5th February 2025

Application No: AW/1/25/HH
Site Address: 27 Aldwick Avenue Aldwick PO21 3AQ
Description of works: Part single, part two storey side and rear extensions, conversion of garage to habitable use, hip to mansard roof extension with dormers, and alterations to fenestrations.

Thank you for your internet representation made on 5th February 2025 which has been recorded as an objection with the comments as follows:

Proposed parking

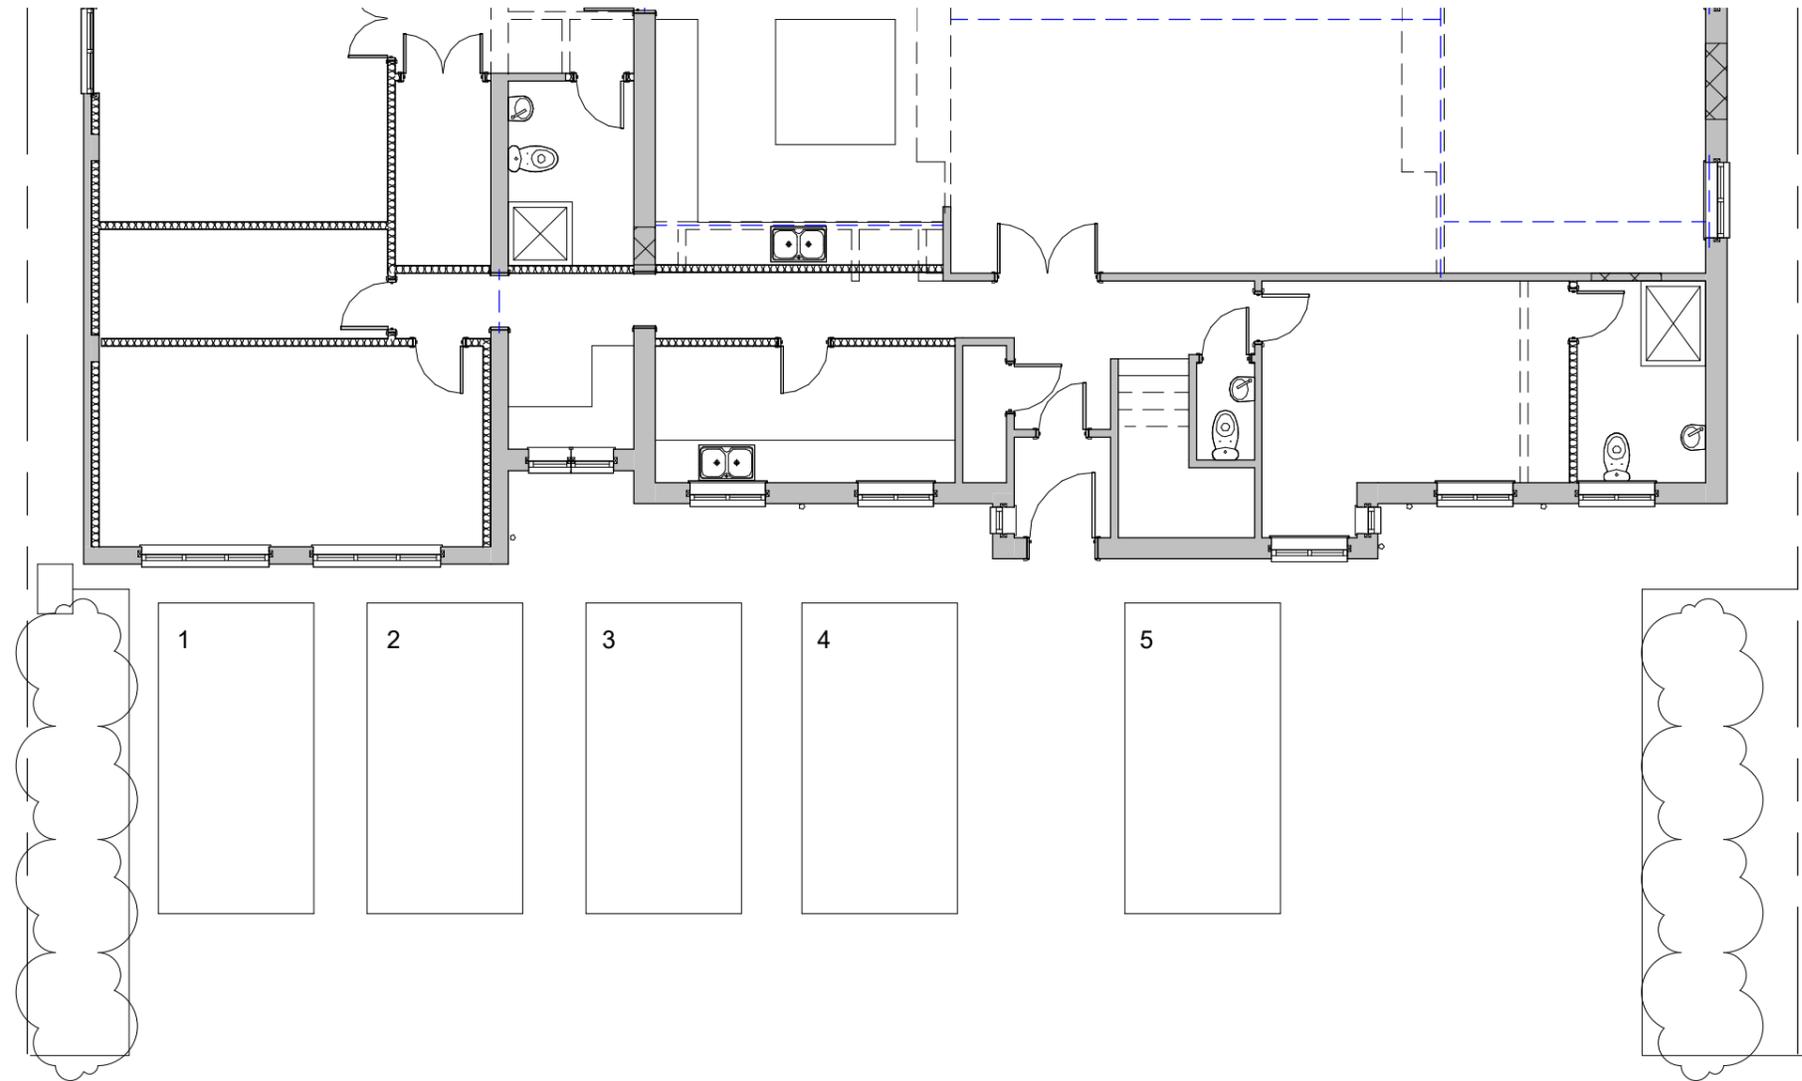
The plan indicates that the existing garage will be used for habitation. There is limited parking on the plot in front of the garage and the road outside the plot is already full of parked cars. I object on the basis that this planned work will increase parking congestion where there is already friction and some unrest between neighbours with existing parking arrangements.
